Engineers Comments Regarding Surface Water Drainage

Application Reference:	Y/65/23/DOC	Reviewer Reference:	ADC/EXT2/D2134/24
Planning Officer:	Simon Davis	Date of Review:	15.08.2023
Site Name:	Bonhams Field Main Road Yapton BN18 0DX		
Application Description:	Approval of details reserved by condition imposed under reference Y/1/17/OUT, relating to condition no 13 - Surface water drainage scheme implementation and 15 - Surface water drainage scheme management. (Plots 2-3 only)		
Assessment Number:	1 of 2

Application Reference: Y/65/22/DOC	Initial Issue Date: 15.08.2023
Site Name: Bonhams Field Main Road Yapton BN18 0DX	Issue Date: 15.08.2023
	Reviewer Reference: D2134/24

SW08

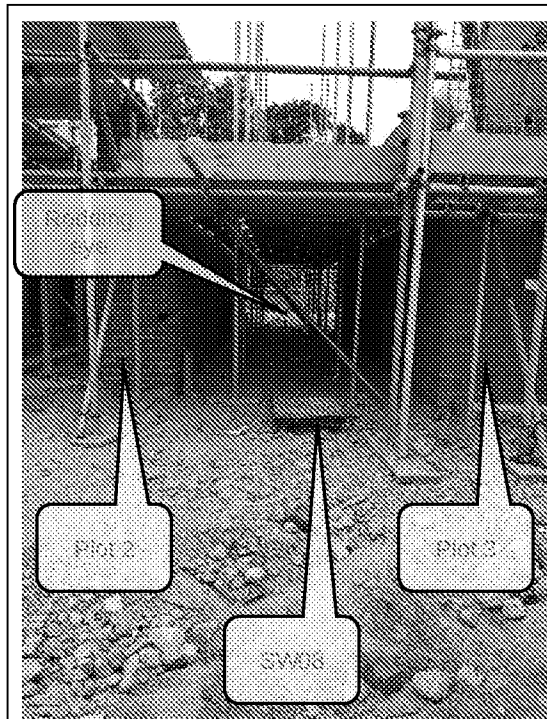
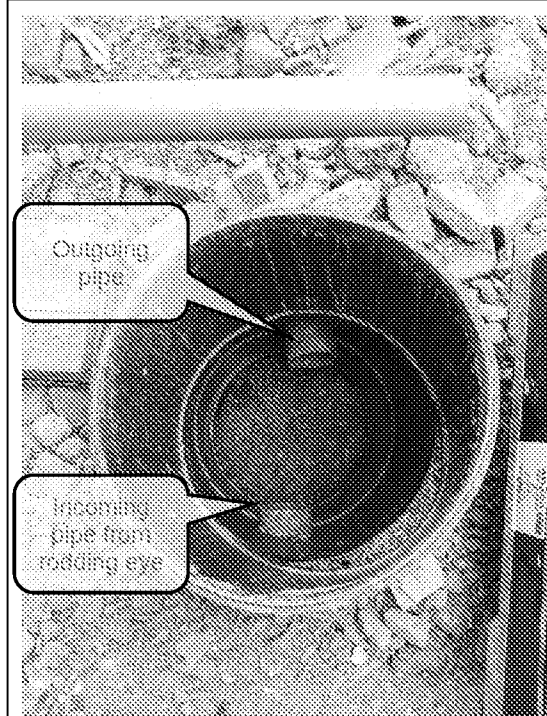
7.	As per item 4.1.3/4.1.4, please confirm final detailing.				
8.	As per item 4.1.5, please confirm final detailing for SW08 & SW10 is complete.				
	SUDS Maintenance Report

Appendix A As Built Drainage Drawing

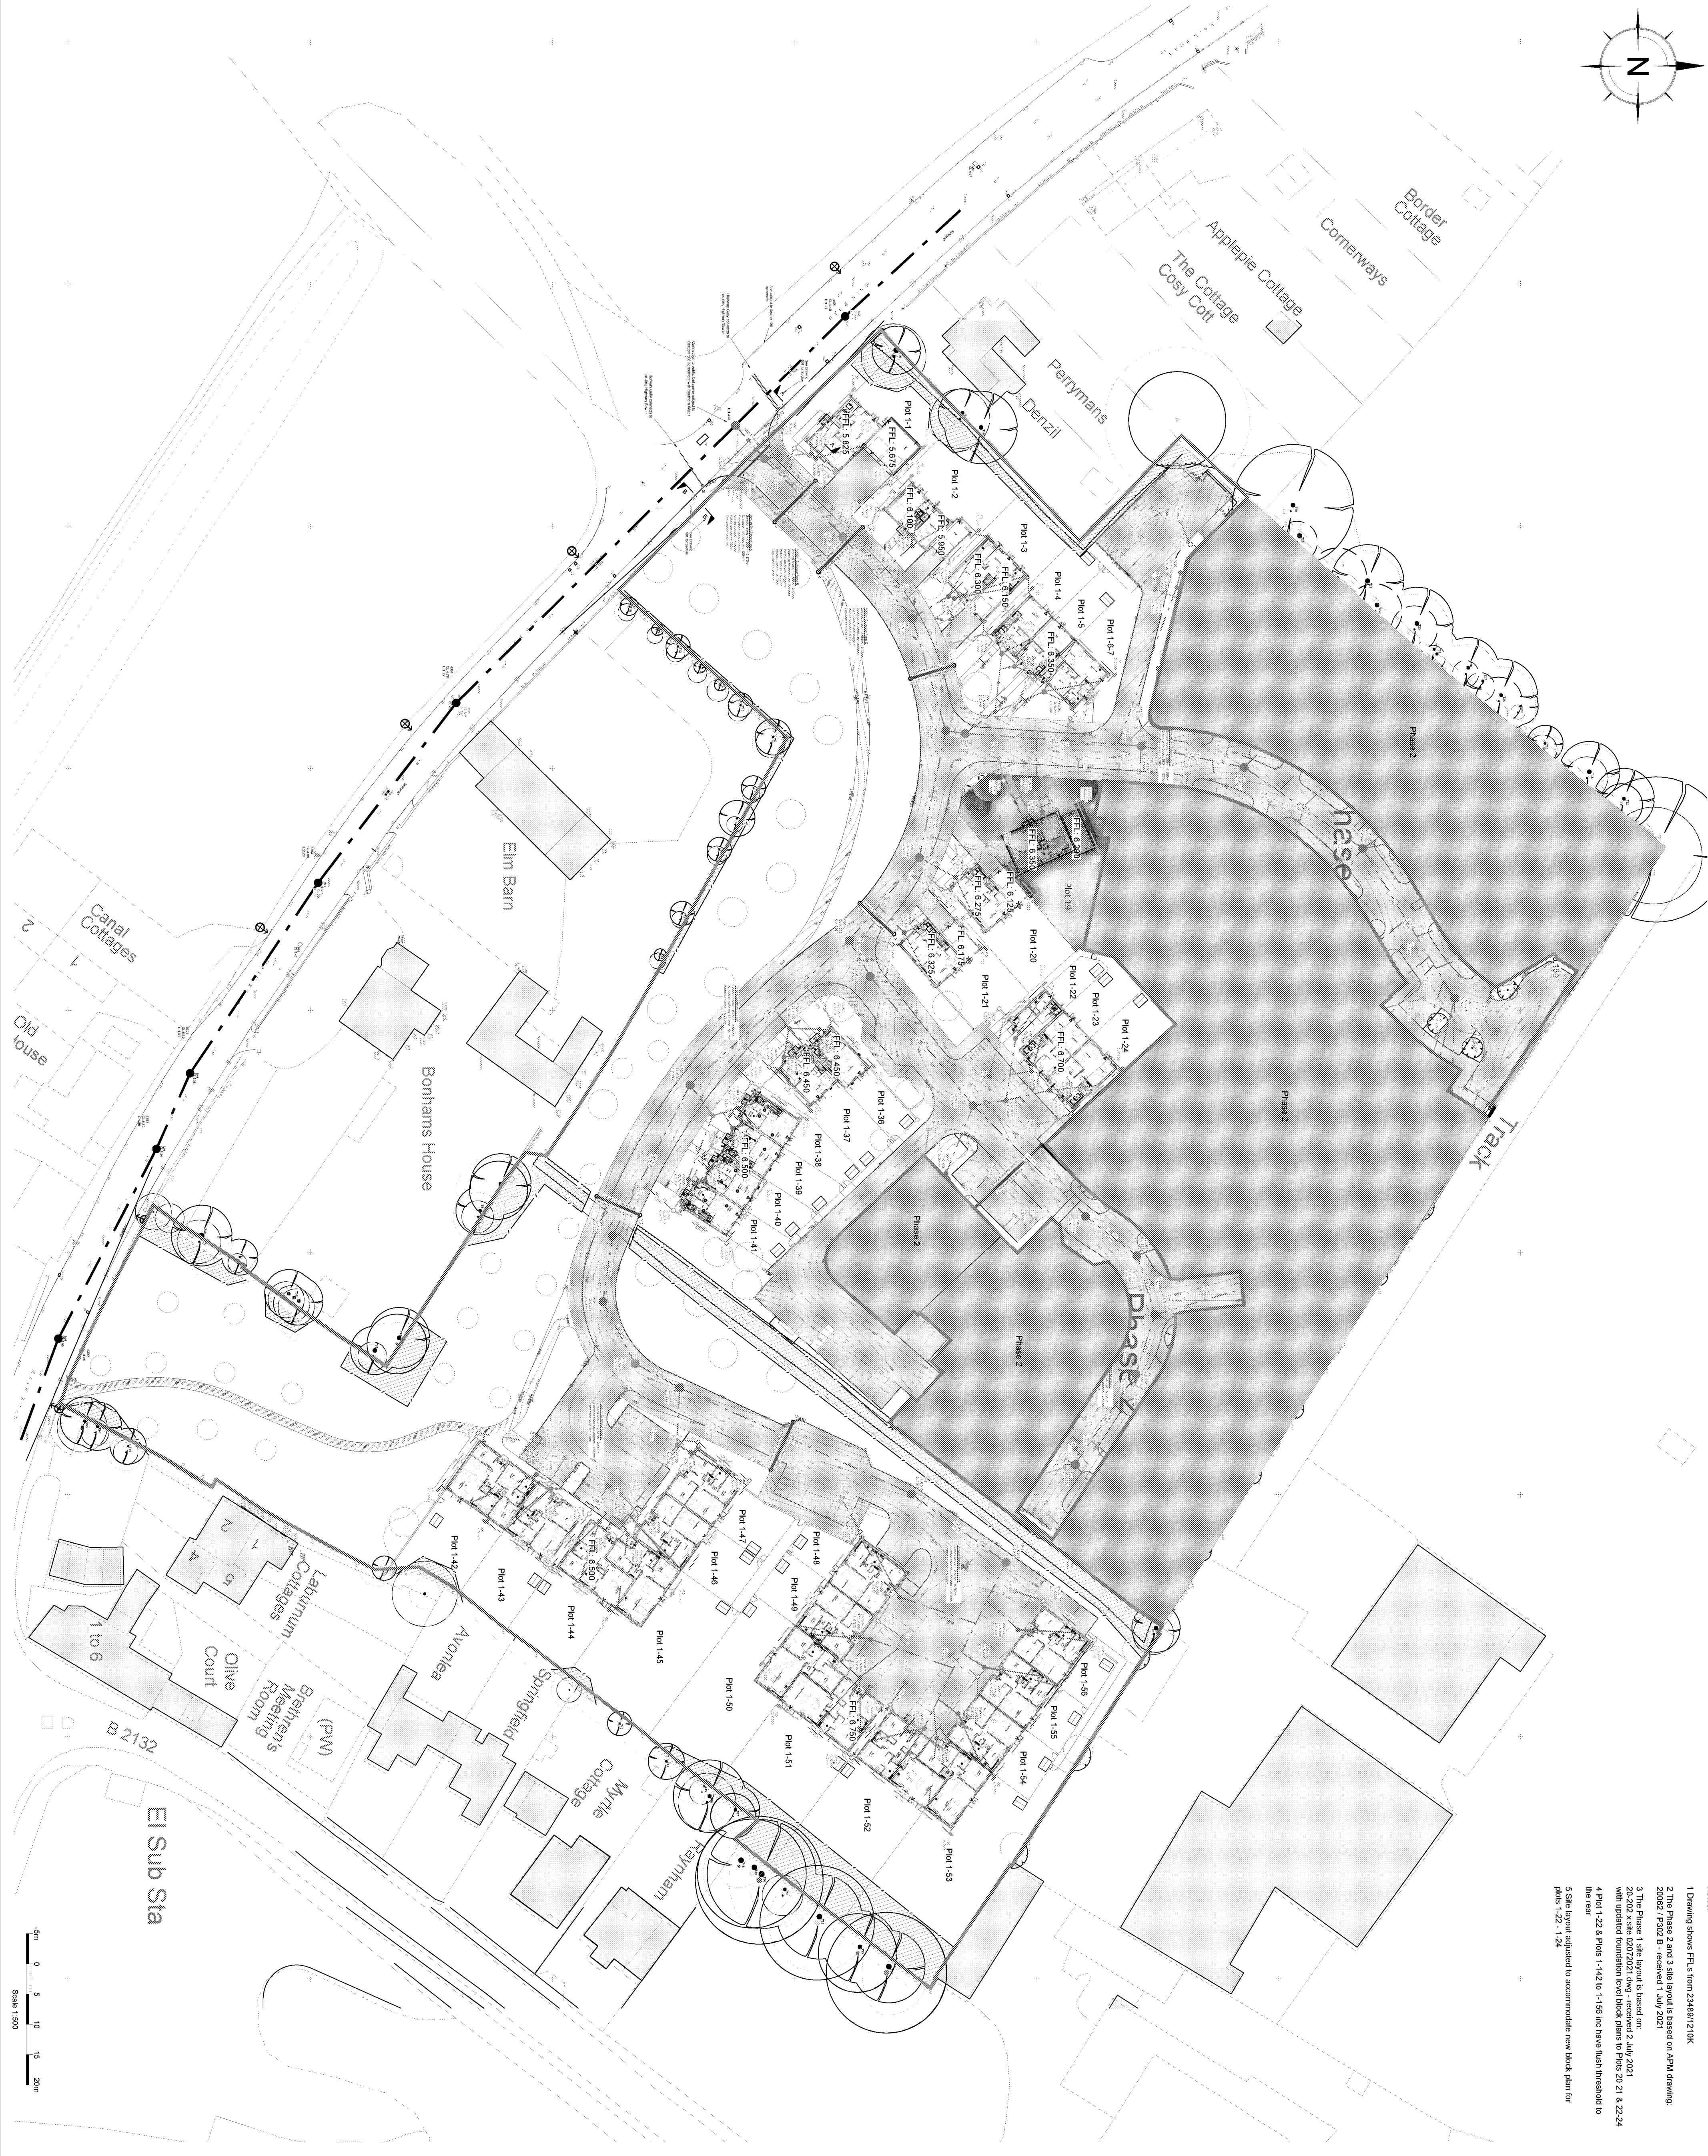
5.	The verification report and supporting information does not meet the requirements of ADC verification guidance note as per the website.				
6.	As per item 4.1.2, please confirm that the position and invert for FW102.
